Planning Officer: Lynnyrd Wolfe

Planning Application Ref: FP/154/19/T

Location: 33 Roundle Avenue, Felpham, PO22 8LL

Description of works: Crown lift by 4m on circumference of tree to allow 6m over road to 1no. ash tree

33 ROUNDLE AVENUE

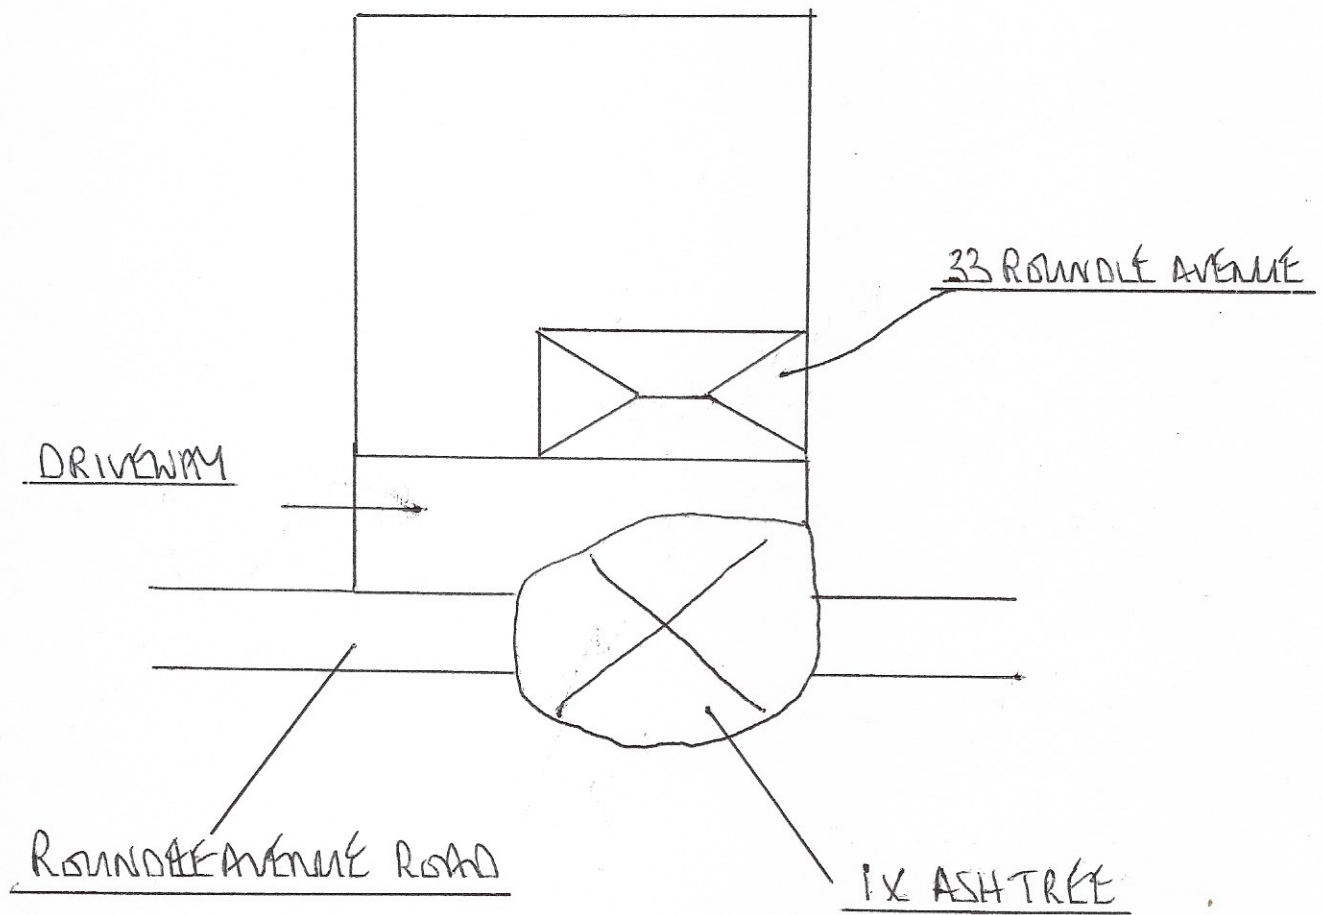
- This tree had been 'topped' at around 5m height but has grown-on well and presents an attractive crown profile. Outwardly and from a distance it appears to be in a fine physiological state and structurally sound.
- It grows at the front of the property and is prominent roadside, being visible from both numerous properties and to traffic across this part of the estate. As such, it has public amenity value.
- The applicant seeks to remove/reduce low branches to achieve no more than 4metres overhead clearance on all aspects; 6metres overhead clearance directly above the carriageway.

- The work proposed is justified on arboricultural grounds as it seeks to strike a balance between the tree's influence and potential impact on surrounding residential property/highway users and the need to retain trees with dignity by having respect for natural tree form.
- If the work is undertaken to a good standard, then it is unlikely to have an adverse effect on the tree's long-term vitality and visual amenity.

- I recommend **CONSENT** for this application, subject to the following conditions:

- Where whole branches are to be removed and final cuts made close to the trunk or branch union they are to be made as shown in Figure 2 of BS3998:2010
- Where branches are to be shortened back the final cuts are to be made at the correct angle shown in BS3998:2010 and adjacent to a live bud or lateral.
